Subject: RE: Planning Consultation on M/15/20/DOC

Engineers Comments Regarding Surface Water Drainage

APPLICATION NO: M/15/20/DOC

Description of Works: Approval of details reserved by condition imposed under M/29/19/HH relating to condition 5-surface water details

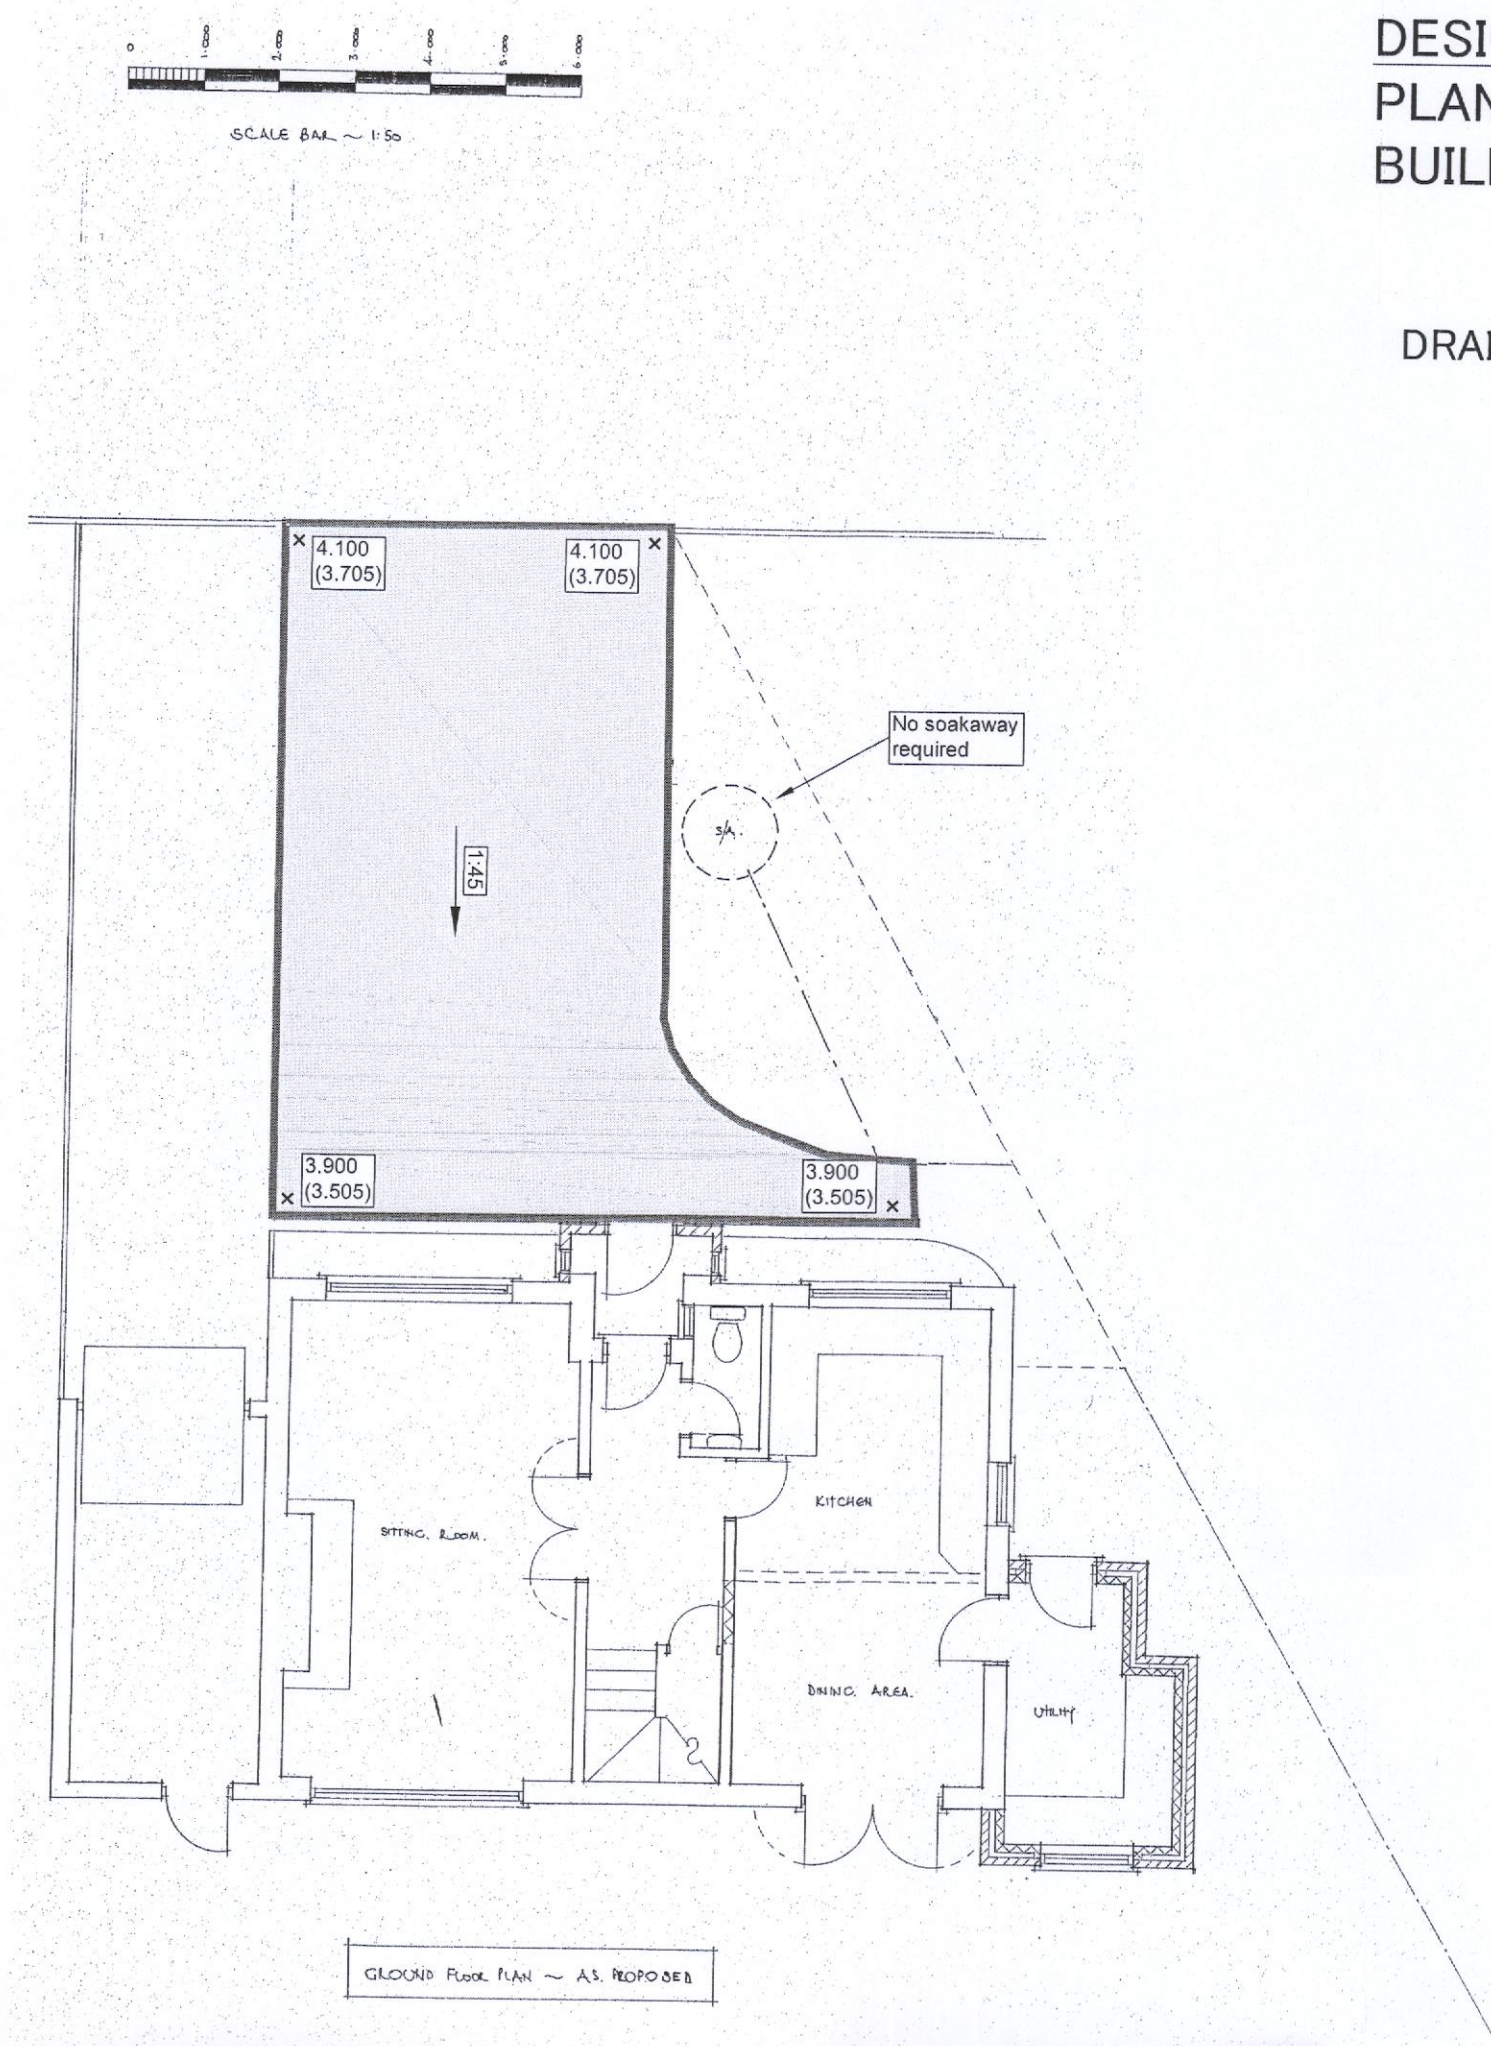
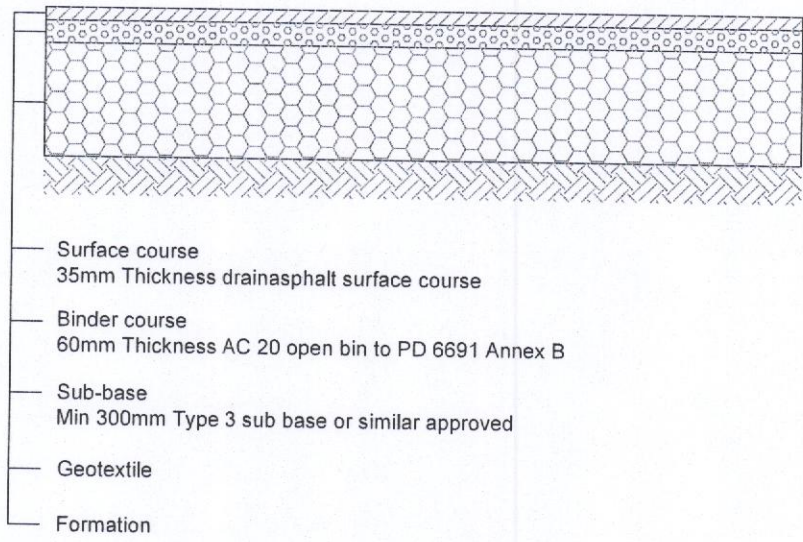
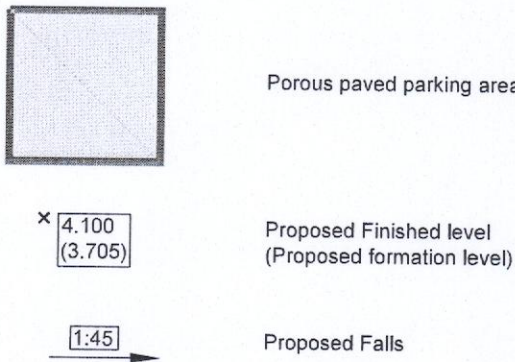
The Drainage Layout shows the location and levels of the permeable paving. Concerningly this appears to show both the finished and formation levels falling at a gradient of 1:45 towards the property. This would result in water flowing towards the building which may compromise the foundations. It is suggested that the formation levels are adjusted to ensure that water flows away from the property, if this is not possible an alternative solution may be required to ensure the stability of the building.

Furthermore, it is understood that the permeable paving is proposed as an alternative to a soakaway, to drain both the driveway itself and the proposed extension and porch. Yet the drainage layout shows no connection of the porch and extension to the permeable paving. However, the calculations **do** appear to account for these additional impermeable areas.

1. The fall of the formation level towards the property.
2. Connection of the proposed extension and porch to the permeable paving via diffuser unit(s) located 5m from the building if possible.
3. Silt trap to be included for surface water entering from the extension and porch.
4. Invert levels of pipes and their diameters.

5. Detail of pipe bed and surround including a note of pipe materials.
